Application by Esso Petroleum Company Limited for the Southampton to London Pipeline Project

Deadline 6 submission submitted on behalf of the Independent Educational Association Limited

Planning Inspectorate Reference No: EN70005

4. IEAL's comments on the Site Specific Plan in respect of St James School [REP4-054]

Illustration 3.1: Plan showing the Order Limits and working strip through St. James School

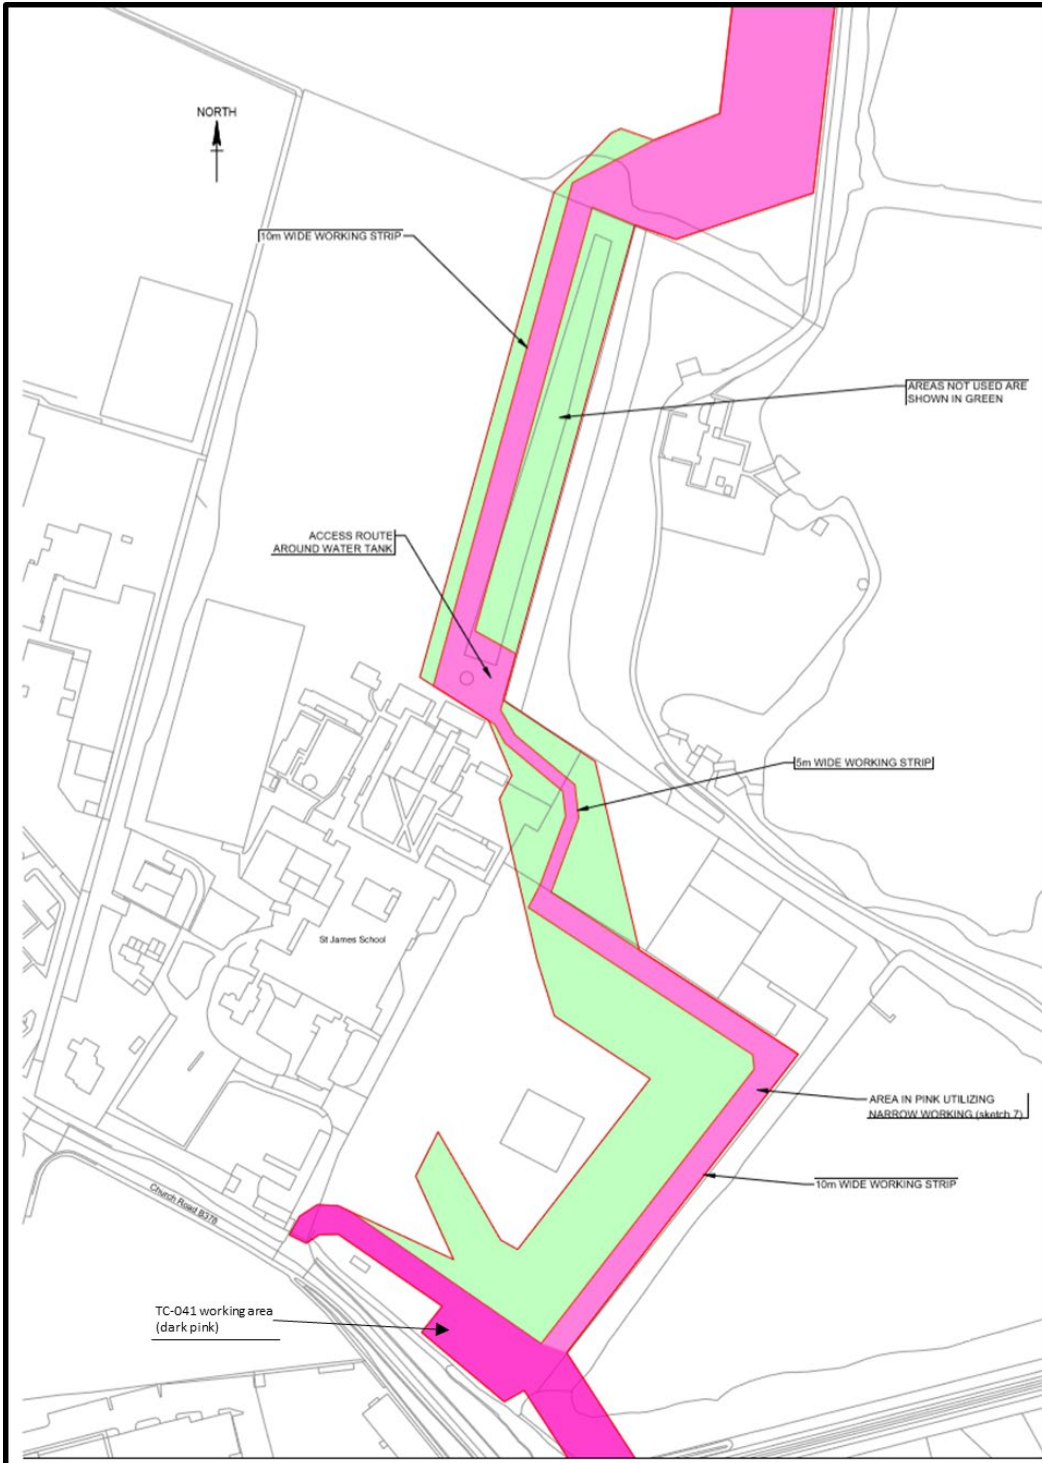
4.2.2.The Order Limits encroach into the boundary of the IEAL's proposed new Assembly Hall. The IEAL notes that a reduced working width of 5 metres is proposed in relation to the works that immediately adjoin the site of the proposed Assembly Hall as shown on the map at paragraph 3.1 of the SSP. The IEAL asks that an express commitment not to exceed the proposed working widths is added to the SSP.

Illustration 3.2: Trenchless crossing from Clarendon School to St. James School (TC041)

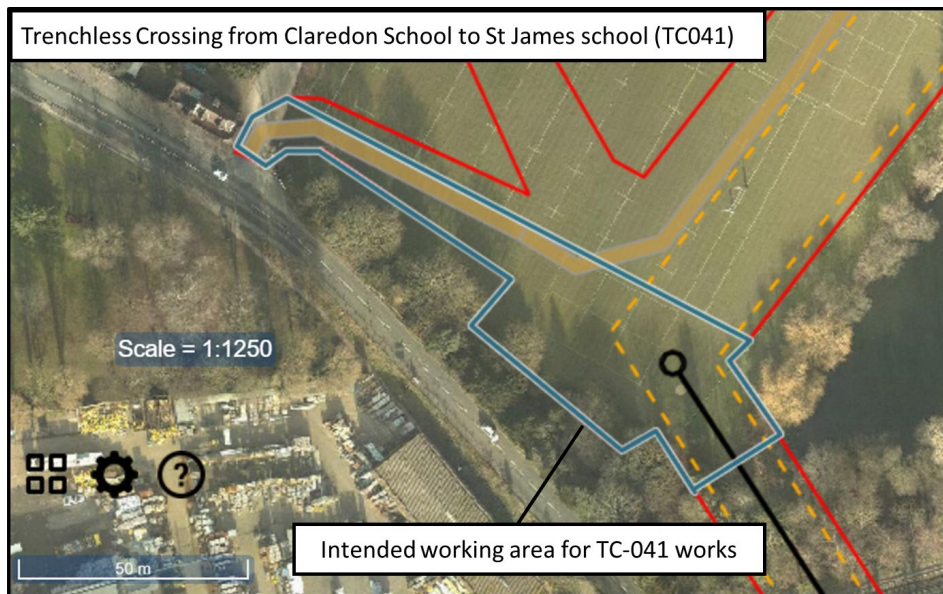
4.2.1.At paragraph 3.4.4 the SSP states: “The stringing out area in the playing fields is not anticipated to be used if the use of an auger bore is agreed with Network Rail.” The IEAL has received no confirmation that the Applicant has reached agreement with Network Rail on this issue which suggests the reduced working areas are unconfirmed.
